From: Andrew Wood
Sent: 25 March 2019 16:56
To: Planning.Responses
Subject: FW: FG/220/18

Subject: FG/220/18

The latest report on this application states that there will be no change to the pond area and resubmitted plans show a clear area all round the pond.

Drawing Title **PROPOSED POND ACCESS
PLAN**

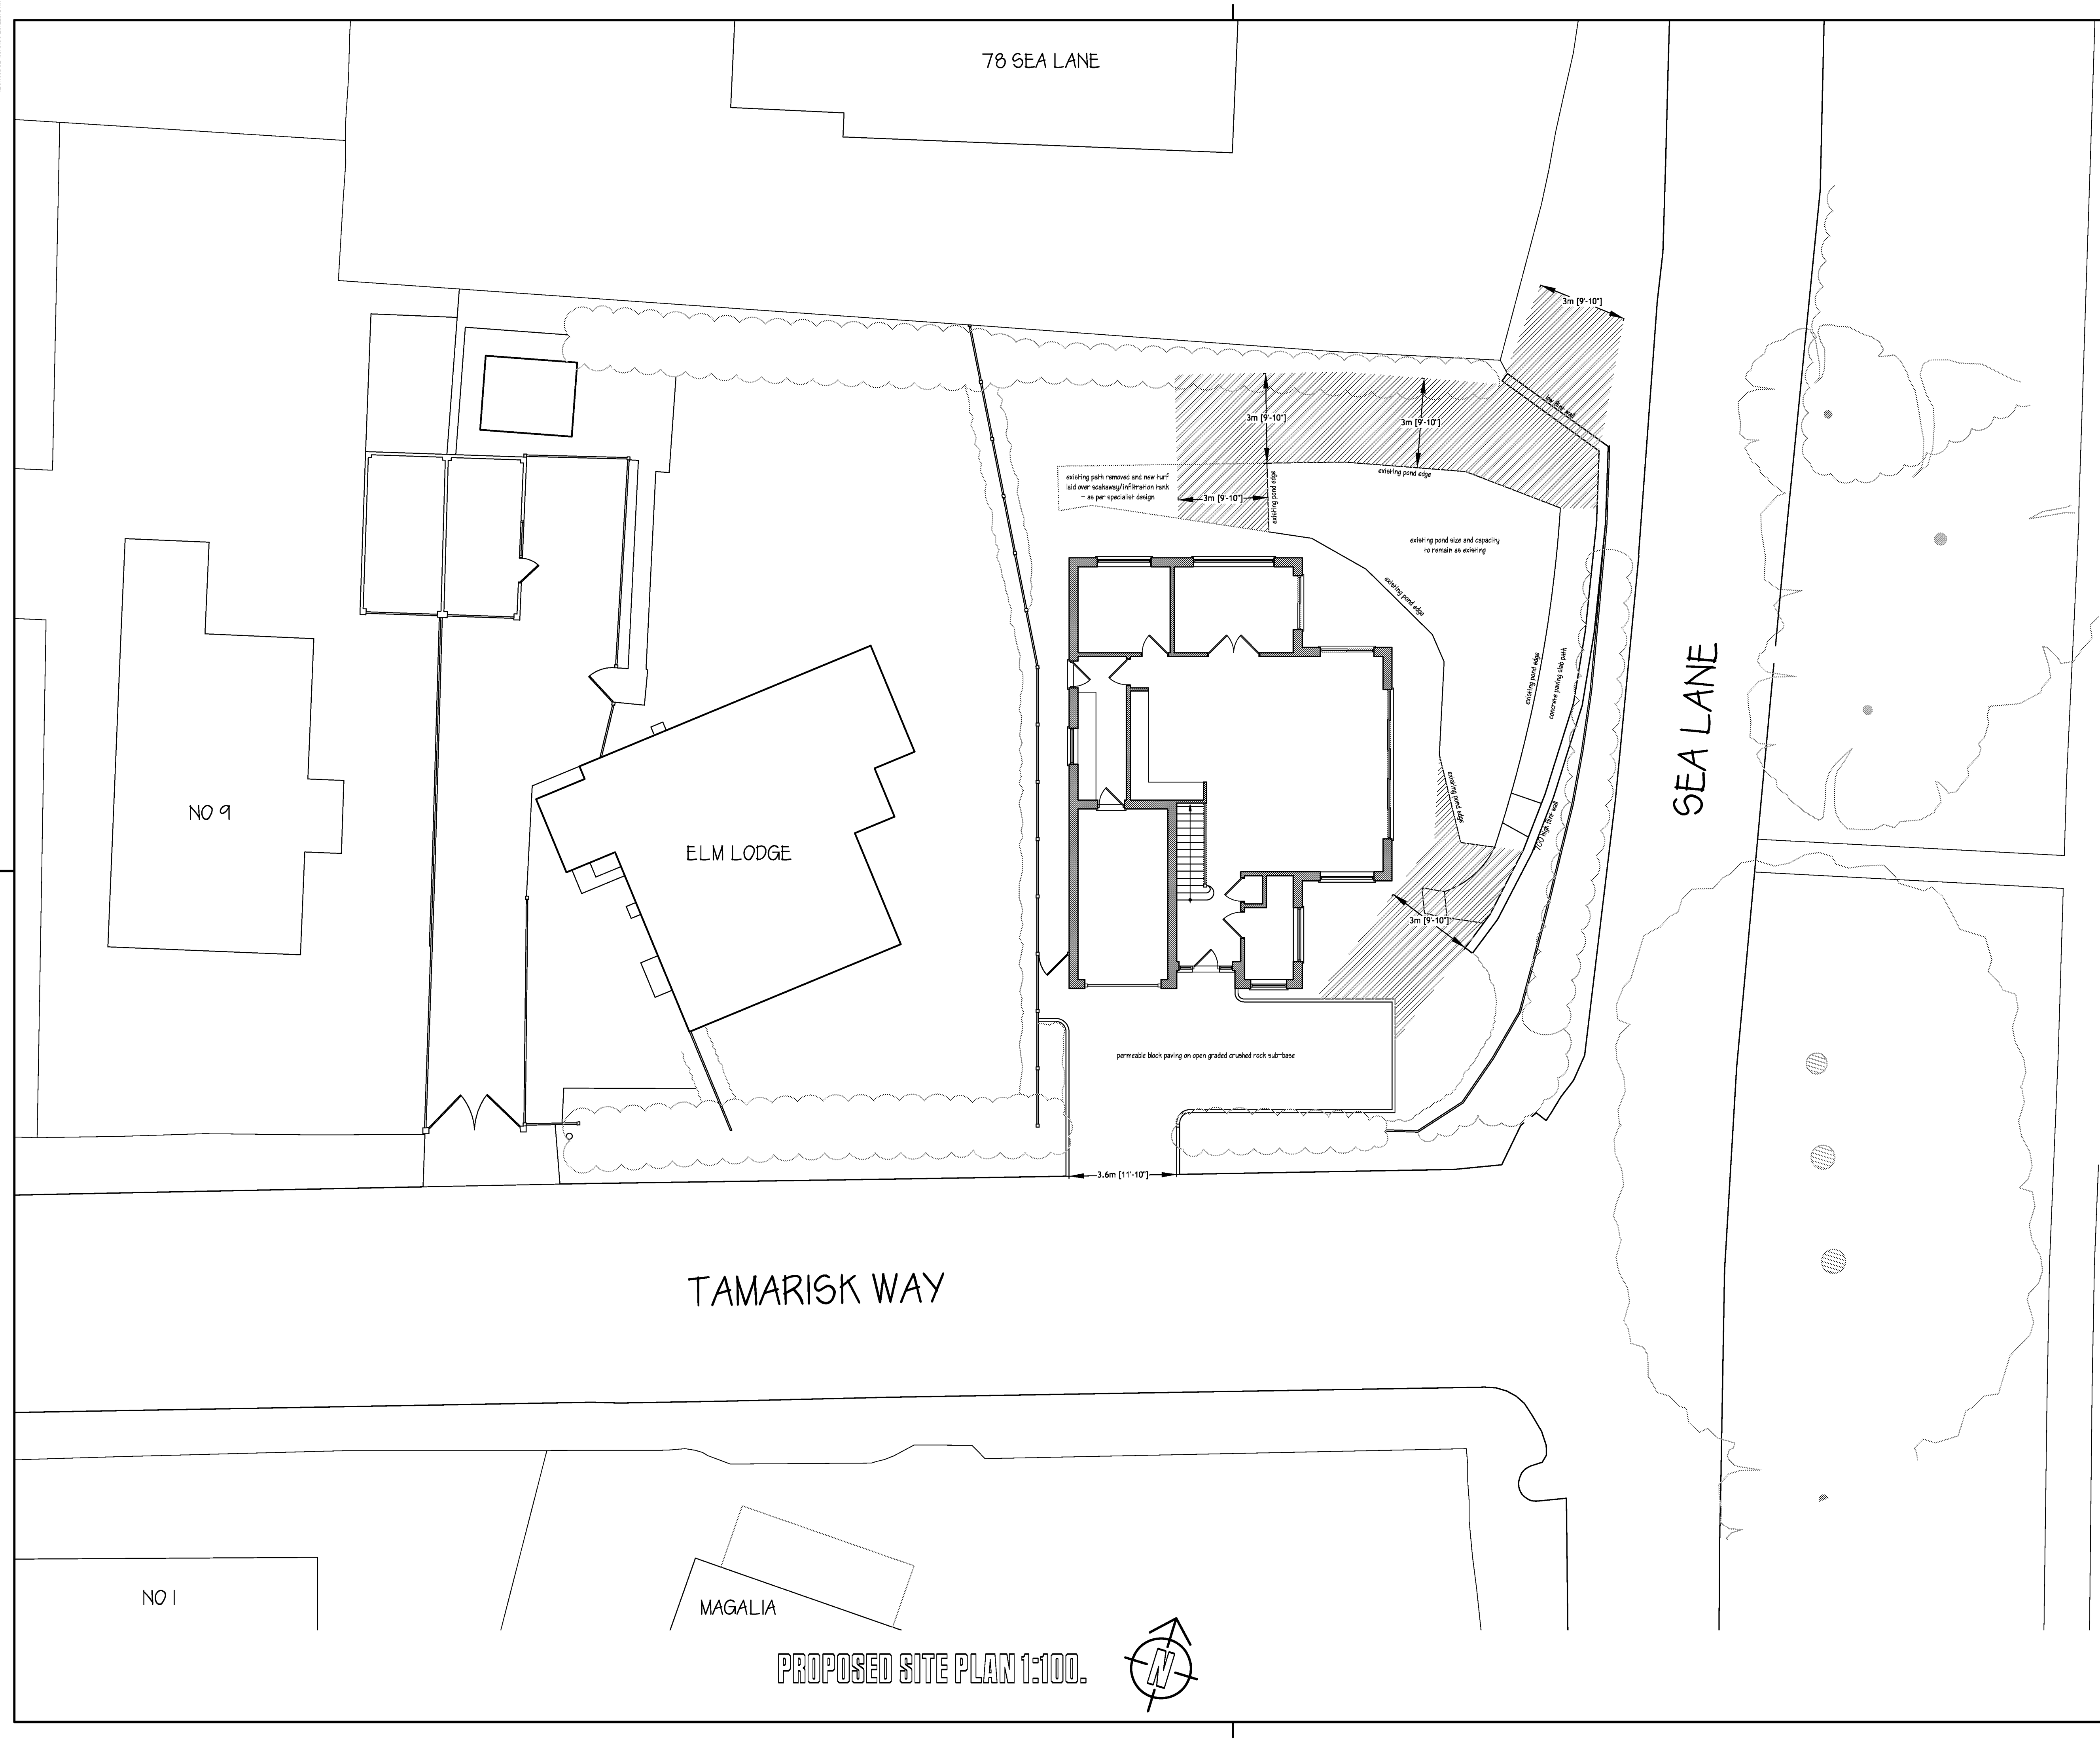
However, the pond area extends fully to the boundary wall on the NE corner of the plot, allowing no easement(ref Laura Gibbons report). The extent of the pond is clearly illustrated in the attached photos and on the land registry document already submitted. This further suggests that notwithstanding small adjustments to the siting of the new building, there is no alleviation to the threat to the drainage system.

We would suggest that this, combined with the large size of the pond, severely restricts the amount of land available to build on.
